**Re: SSD 6954 IKEA Multi-Function Logistics Unit, Sydney Business Park,
Marsden Park**

The proposal has been reviewed by Council officers and is not supported in its current form. A range of issues have been raised and listed in **Attachment A** to this letter, which are requested to be addressed to Council's satisfaction by the Proponent before any determination of the proposal is made by the Department. Council requests the opportunity to provide conditions of consent prior to the determination of the application.

ATTACHMENT A

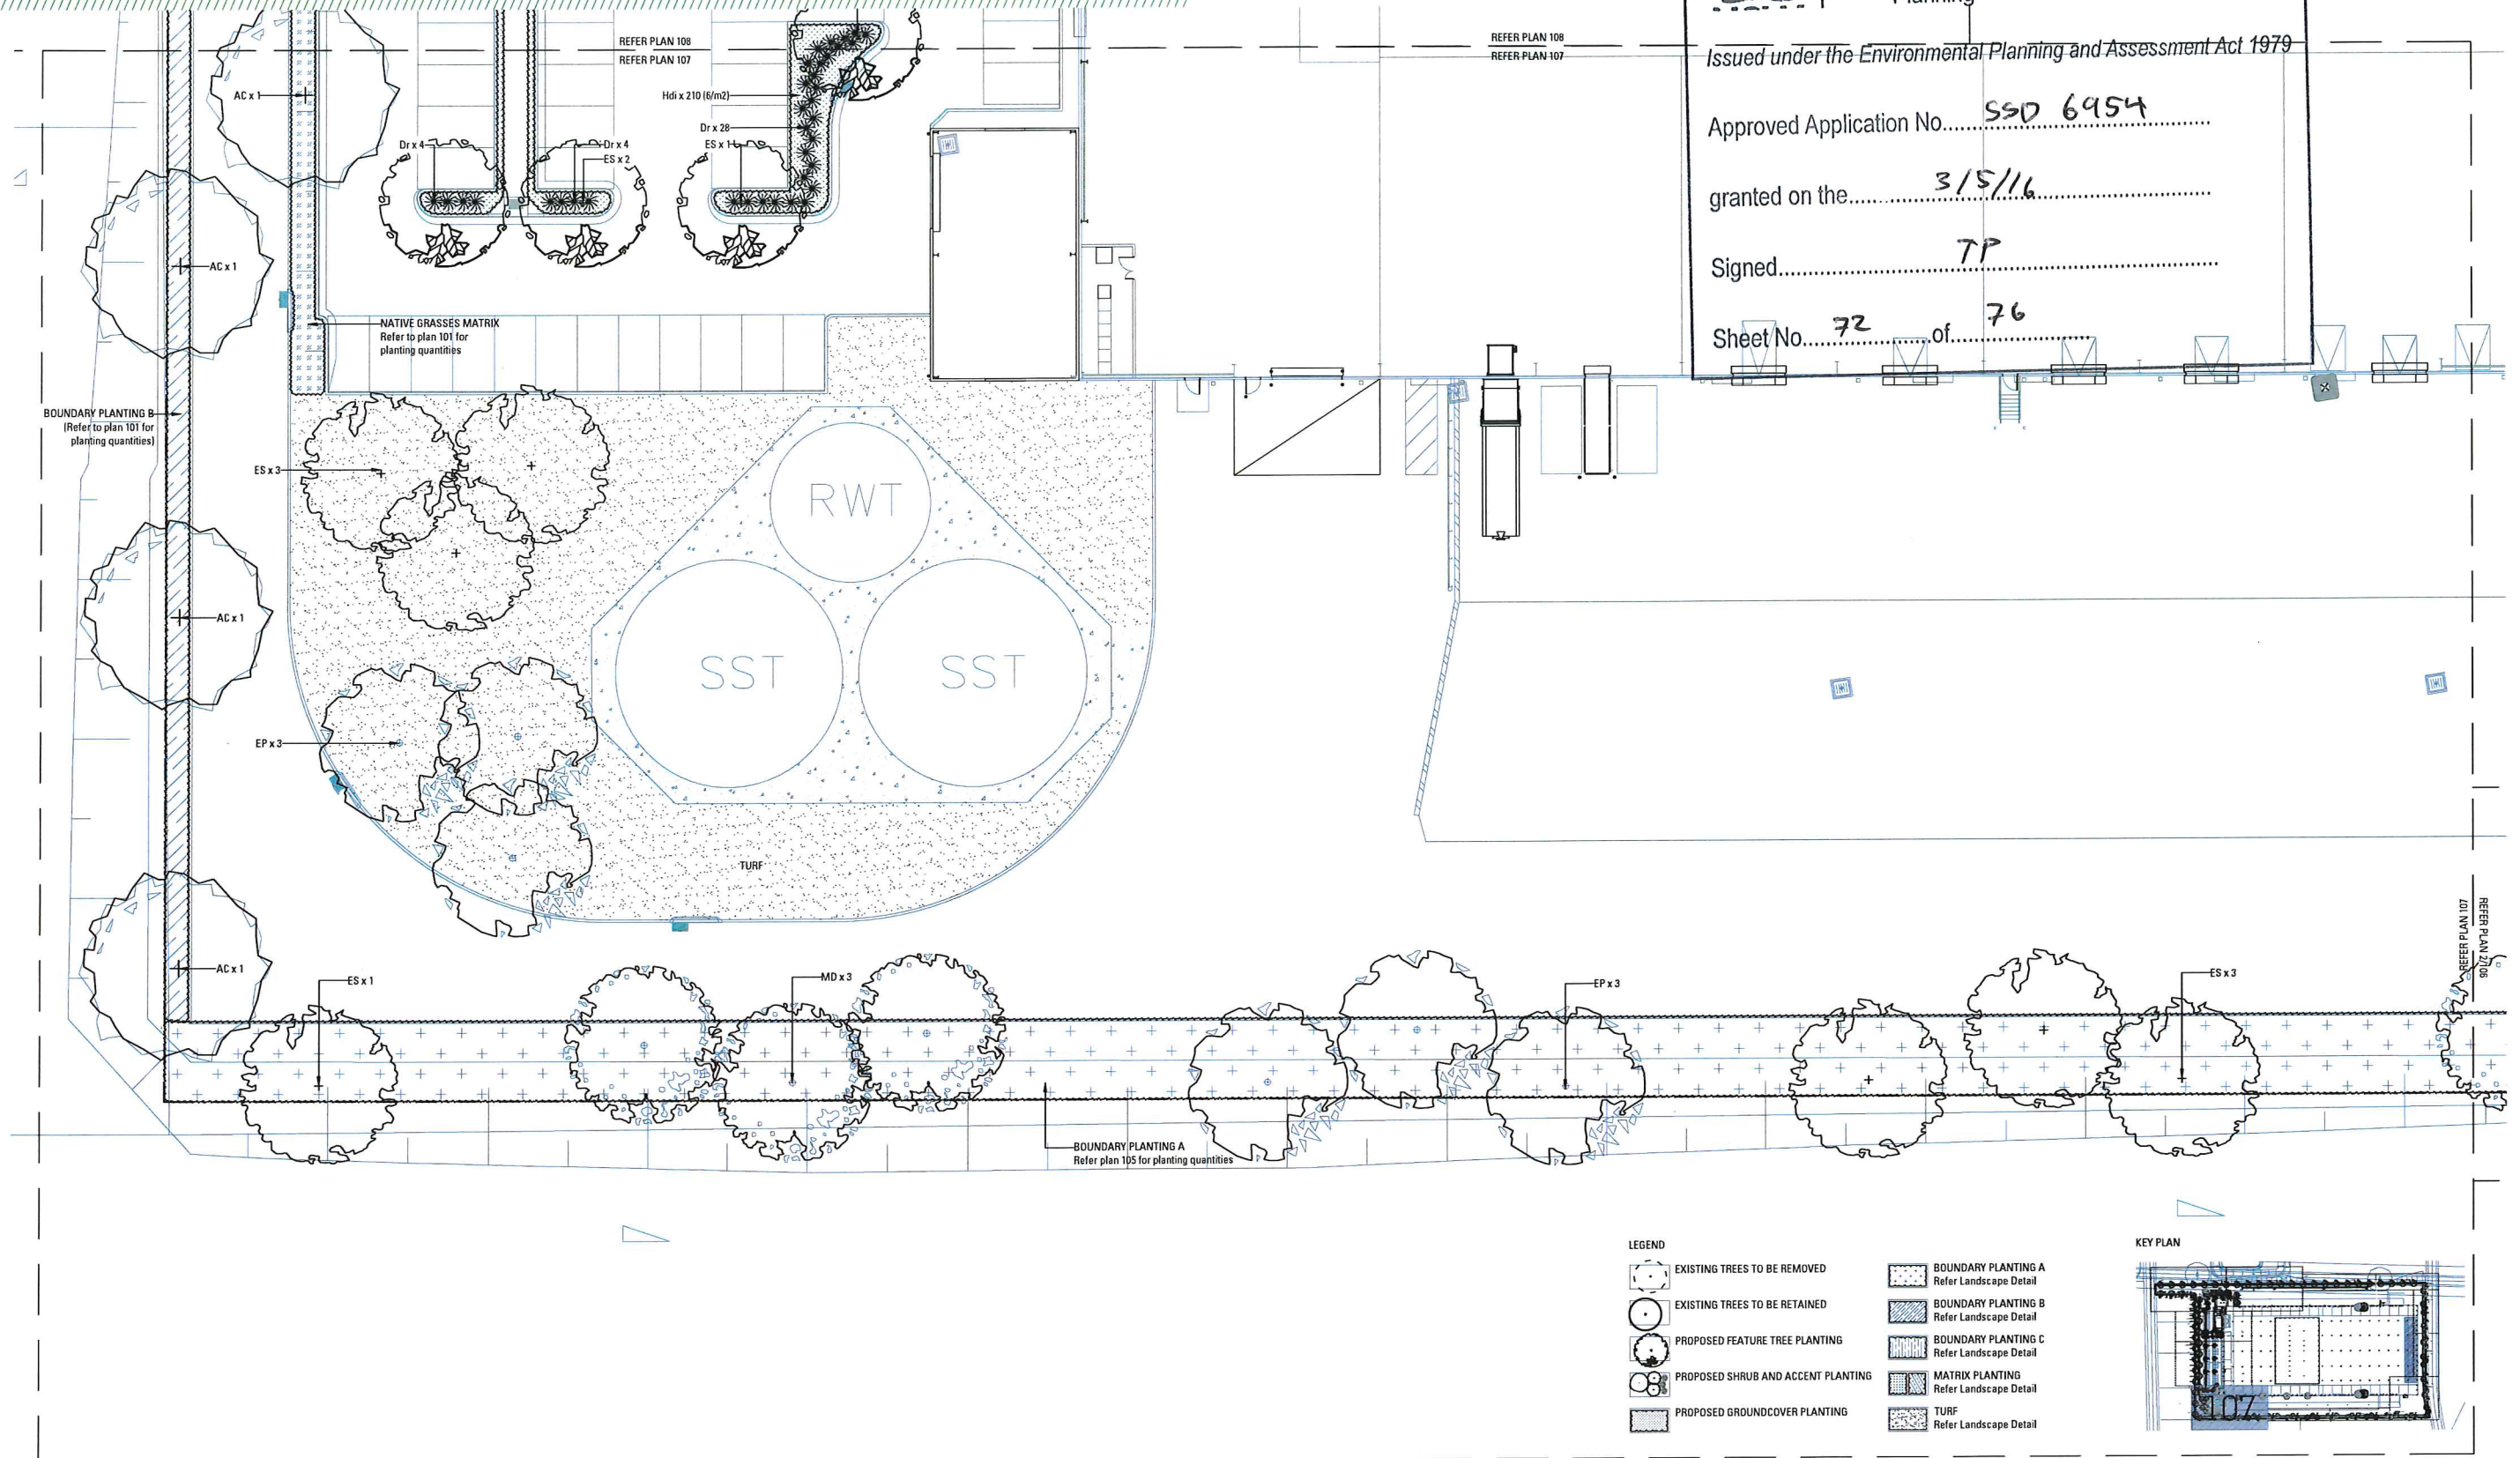
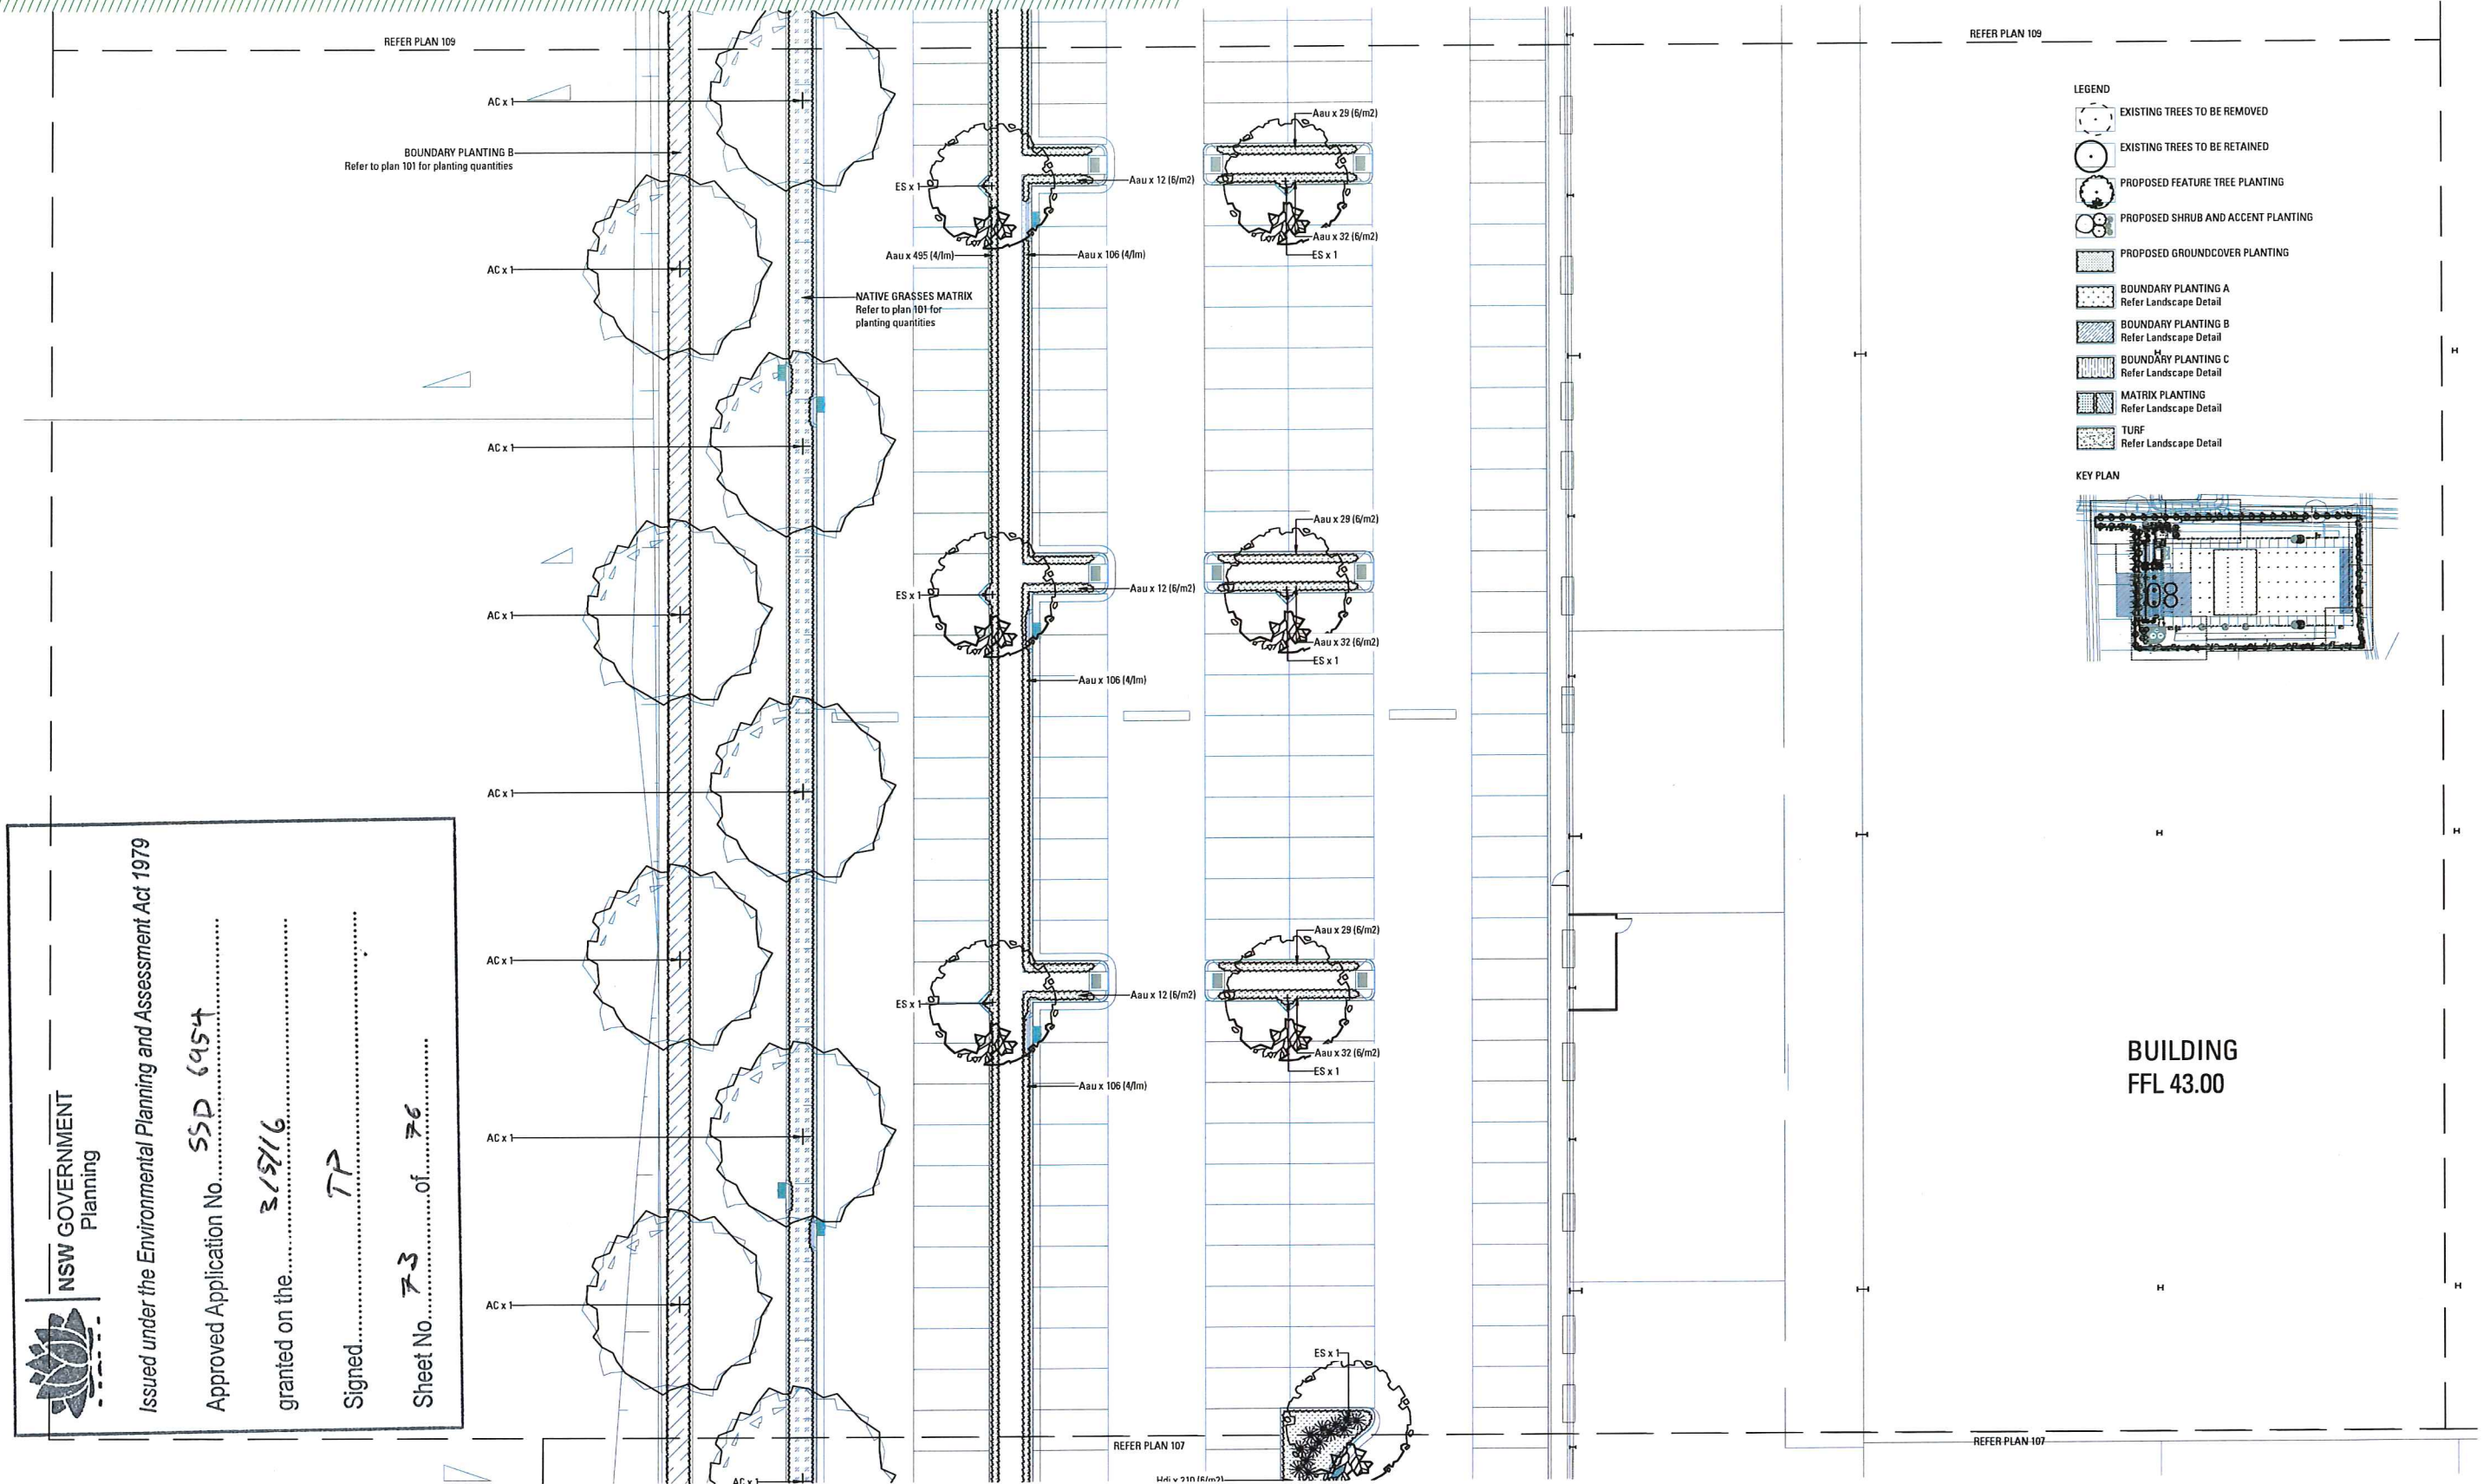
5. The proposed landscape plans demonstrate a suitable design of trees and plantings, however concern is raised that the proposed pot sizes are not satisfactory. Therefore, suitably sized trees, shrubs and plantings are required to be demonstrated on the plans which demonstrate that the resulting planting will suitably complement the proposed building and reach maturity in a suitable timeframe.
